**WELWYN HATFIELD BOROUGH COUNCIL
EXECUTIVE DIRECTOR - PLANNING, PUBLIC PROTECTION AND GOVERNANCE**

DELEGATED APPLICATION

Application No: 6/2019/2313/FULL
Location: 101 Brookmans Avenue, Brookmans Park, Hatfield, AL9 7QG
Proposal: Erection of six dwellings following demolition of existing buildings
Officer: Mr David Elmore

Drawing Title
PROPOSED SITE PLAN

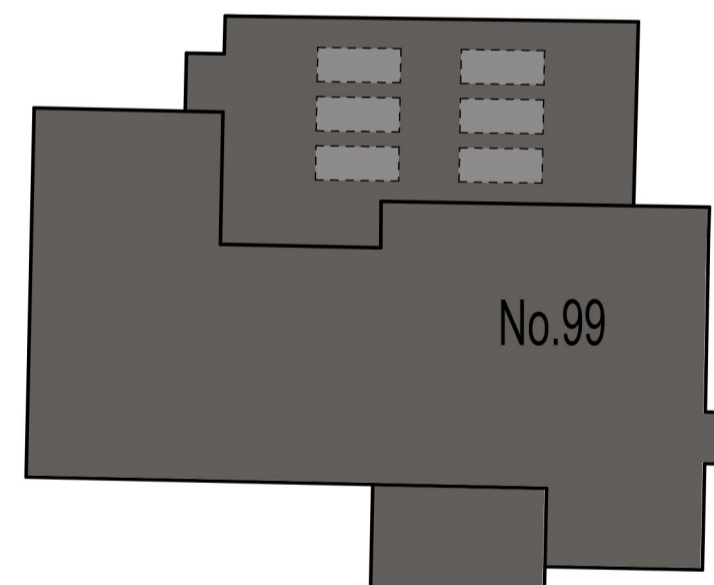
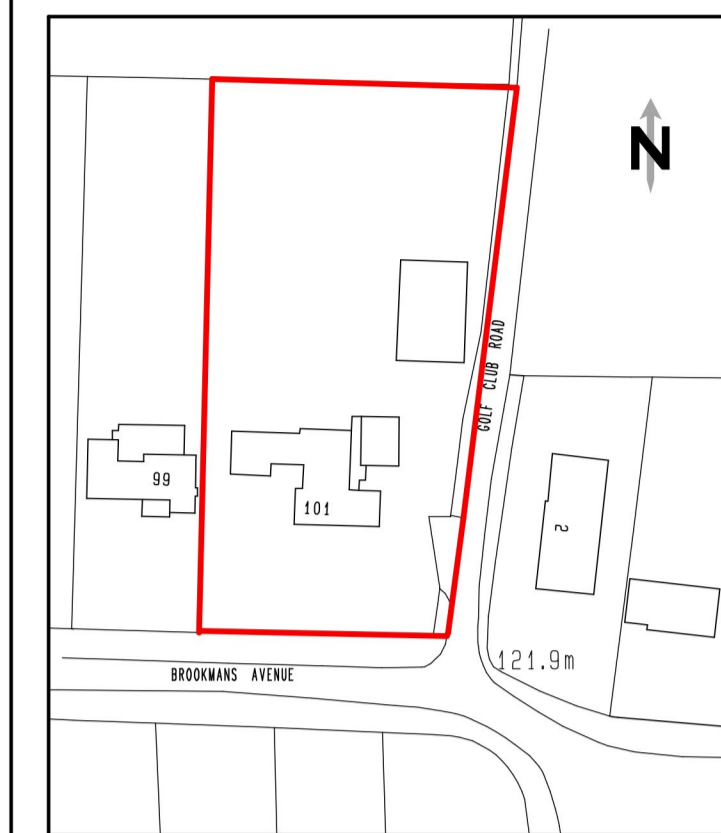
In terms of drag distance, the proposed site plan shows that bin stores for each dwelling would be adjacent to their individual entrances, so drag distance to the boundary with the highway would be minimal.

4. Prior to first occupation of the development hereby approved, vehicular access must be provided and thereafter retained at the positions shown on drawing number 485018-16 Rev B. Arrangements must be made for surface water drainage to be intercepted and disposed of separately so that it does not discharge from or onto the highway carriageway.

Drawing Title
EXG SITE SECTIONS
AND STREET SCENES

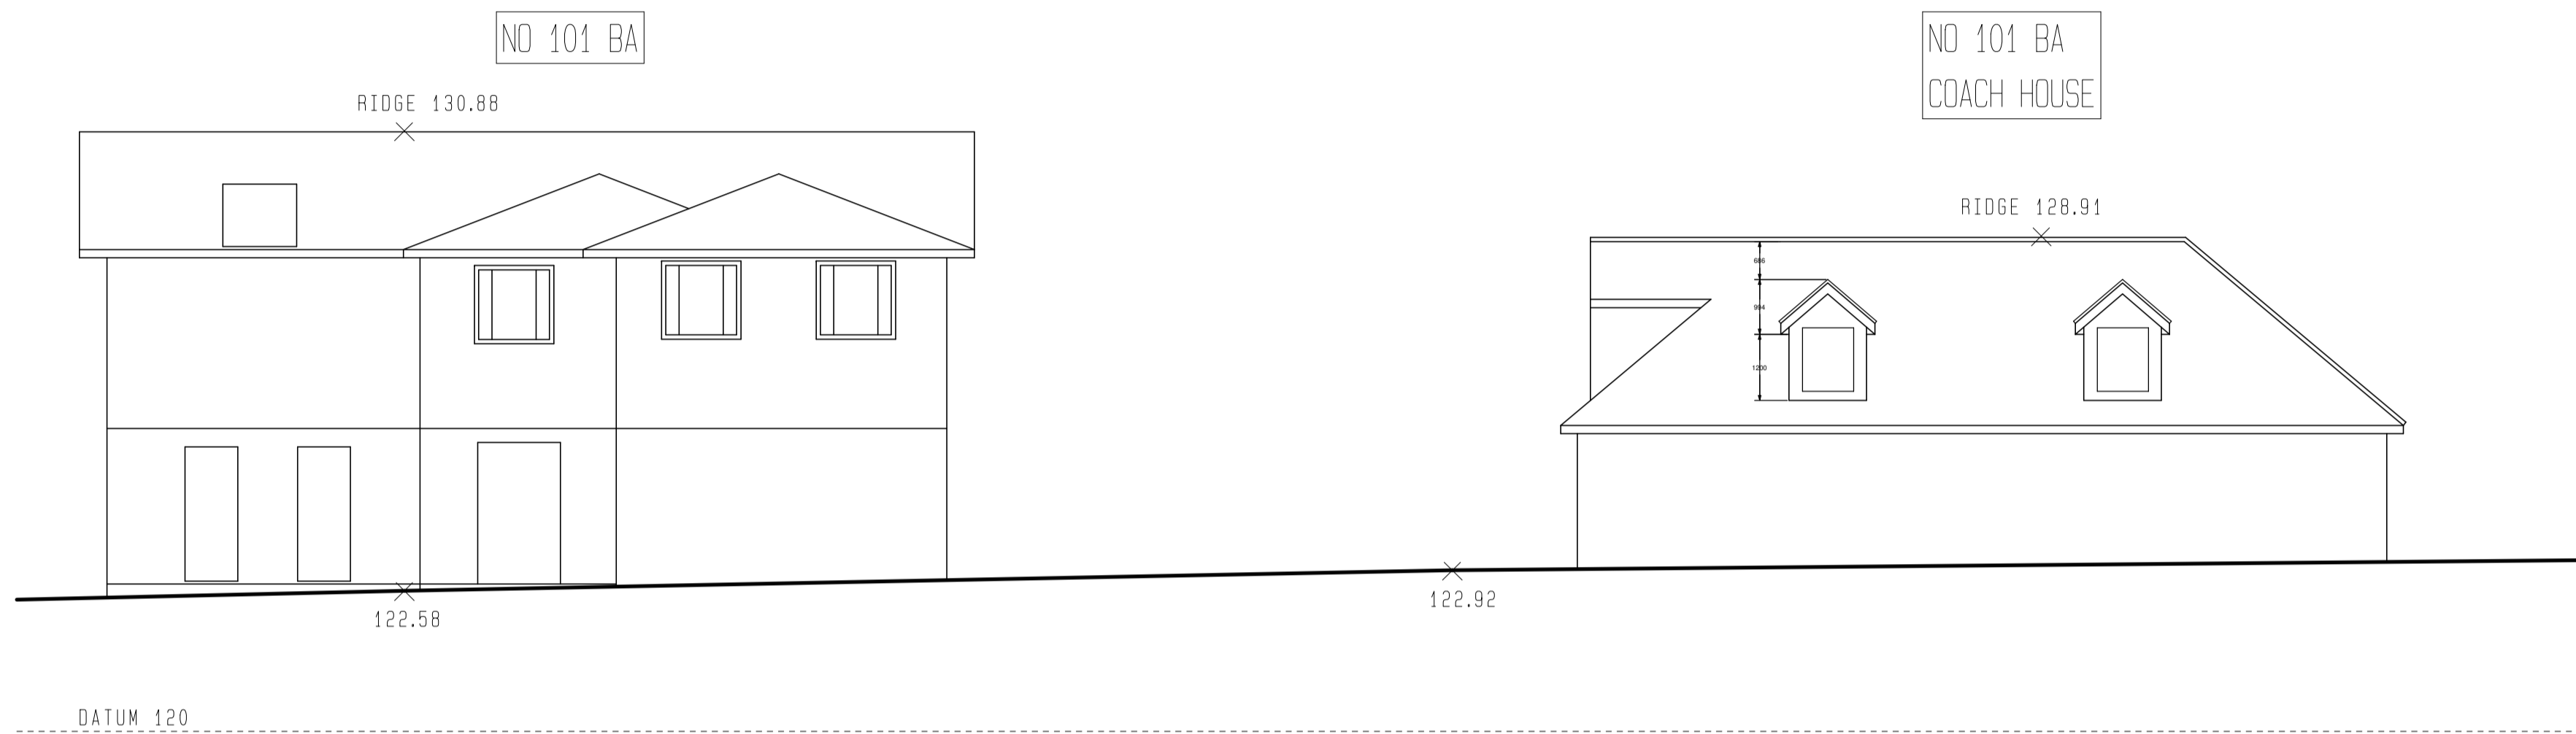
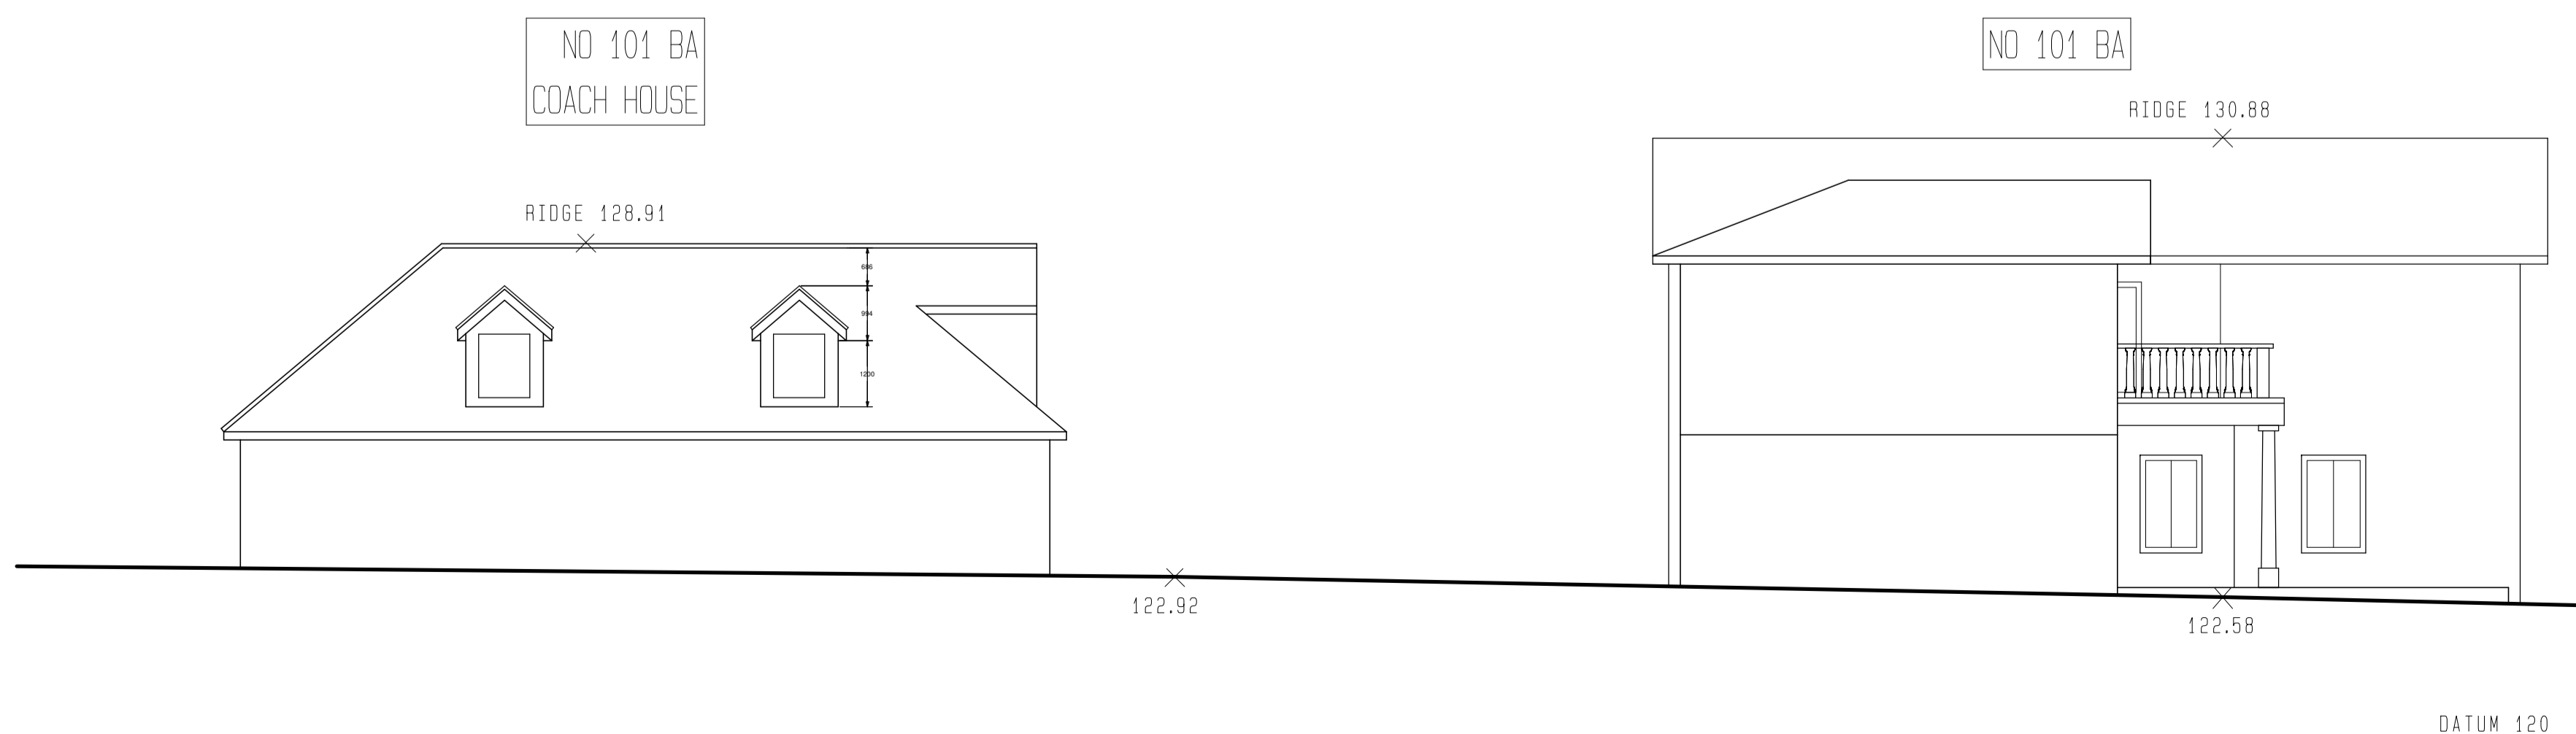
Units 1, 2 & 3 would have a height of 8.9 metres, whilst Units 4, 5 & 6 would have a height of 8.8 metres. The representation received from number 99 Brookmans Avenue considers that the proposed dwellings would be greater in height than this property as they include habitable roof accommodation, not of matching height, as shown on the proposed streetscene drawing.

The accuracy of many streetscene drawings are understandably questionable as, in many cases, there has been no access to neighbouring sites to take precise measurements. It is also noted that the proposed street scene drawing also annotates that the eaves of 99 Brookmans Avenue as approximate.

To ascertain the height of 99 Brookmans Avenue a planning history search of this property has been undertaken. On the most recent planning permission at 99 Brookmans Avenue (S6/2006/0255/FP) for a single storey rear extension, this dwelling has a height of 8 metres. Therefore it is very likely that the proposed dwellings would be greater in height than this neighbouring property. Notwithstanding this, it is considered that the difference in height would not be significant. The siting of the proposed dwellings on lower natural ground level than 99 Brookmans Avenue would also reduce the perceptible height difference. Furthermore, it is noted that dwellings of very similar height and form to the proposed development exist nearby along the street scene. To this end, it is considered that the height of the proposed dwellings would adequately relate to buildings heights in its immediate context.
